APPLICATION NO. 03DRR-00709	PROJECT NO. 1002530
PROJECT NAME LANDS OF WENDT	
EPC APPLICATION NO.	
APPLICANT / AGENT WAYJOHNSURV. INC.	PHONE NO. 255-2052
ZONE ATLAS PAGE G-14

**CITY OF ALBUQUERQUE
PLANNING DEPARTMENT
Development Review Board
3/19/03 Comments**

PROJECT # 1002530

SUBJECT: Haralson Addition/Sketch Plat

PLAT OF
 LOTS 1, 2, AND 3
 LANDS OF WENDT
 ALBUQUERQUE, BERNALILLO COUNTY, NEW MEXICO

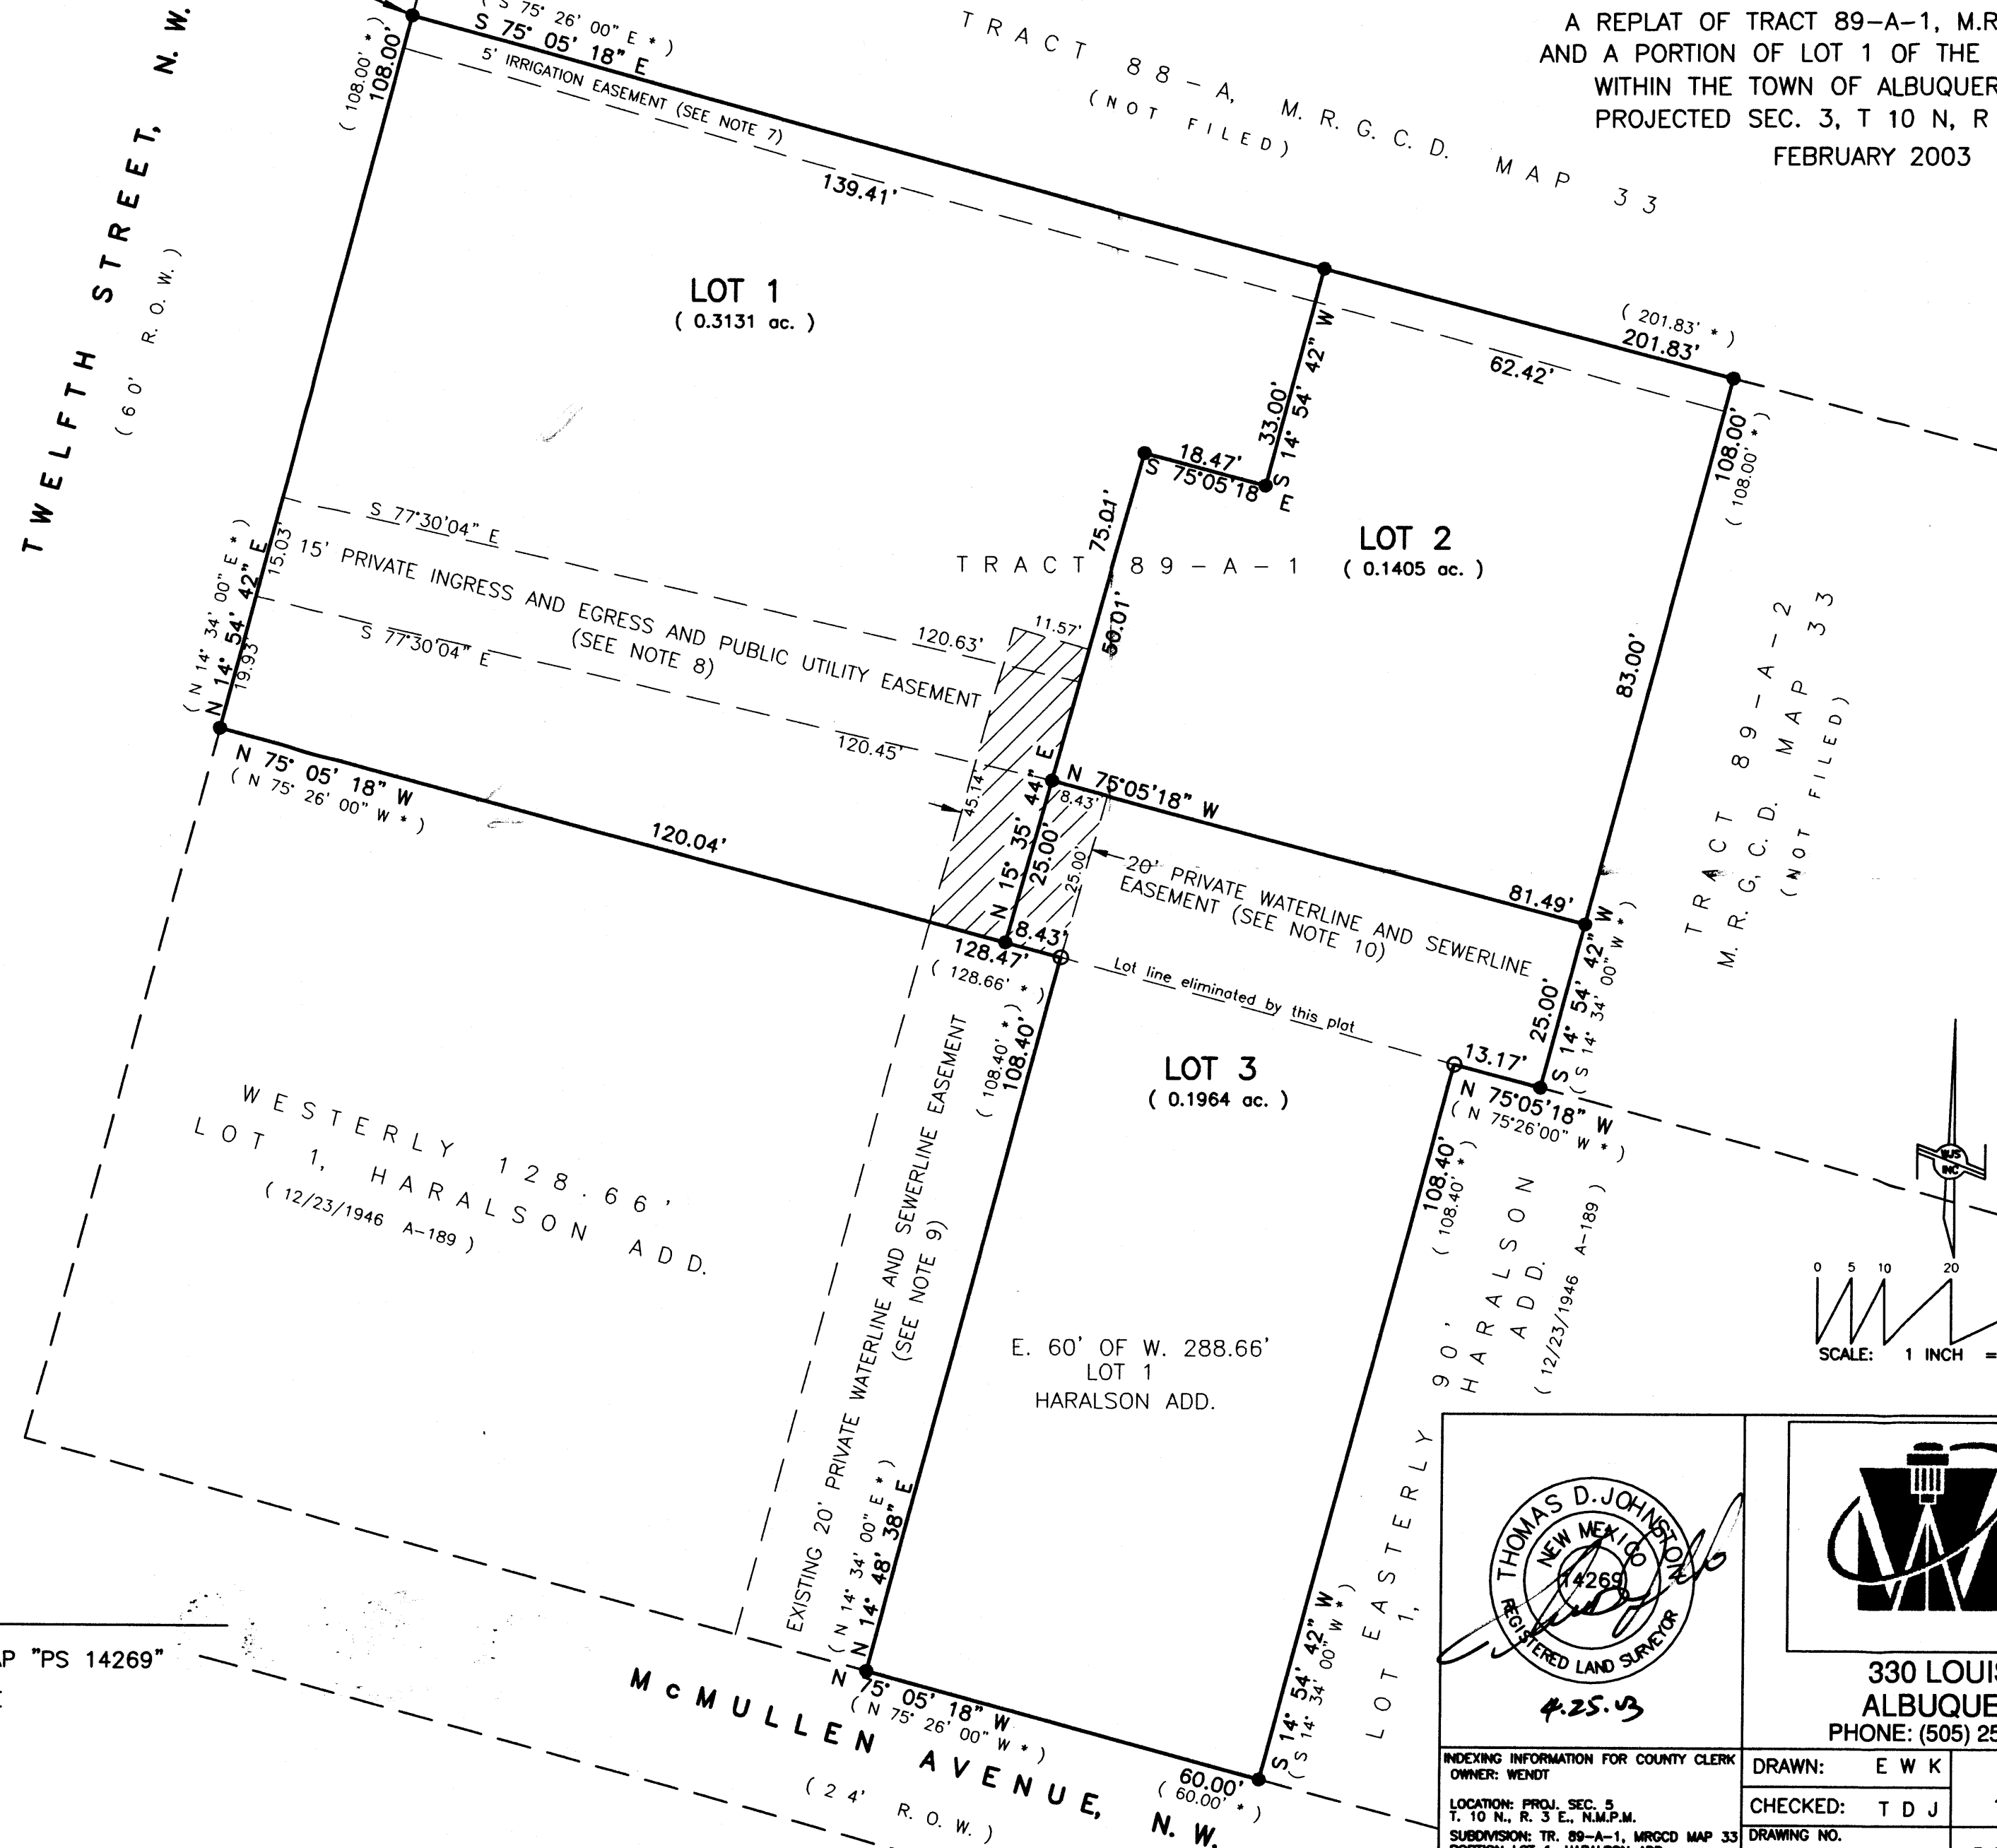
R-1 zoning has required setbacks in the City Zoning Code. The lots as created do not meet all requirements. The buildings on Lot 3, which are assumed to be existing, must be a minimum of 5 feet from the side lot lines. On the west side they are less than 2 feet from the new lot lines. On the east side the house is less than 5 feet from the east lot line. These dimensions should be corrected to meet minimum requirements as these lot lines are new.

The residence and garage on Lot 1, also assumed to be existing, should be 15 feet apart. They are 10 feet apart. If they are existing buildings to be left as is, the 10 feet is okay. If they are going to be moved or demolished, the distance should be increased to 15 feet between buildings.

Also, the residence on Lot 3 is almost a foot short of the required 5 foot setback in the front yard. If this building is to be moved or demolished, please be sure the new or moved building meets the 20 foot required front yard setback.
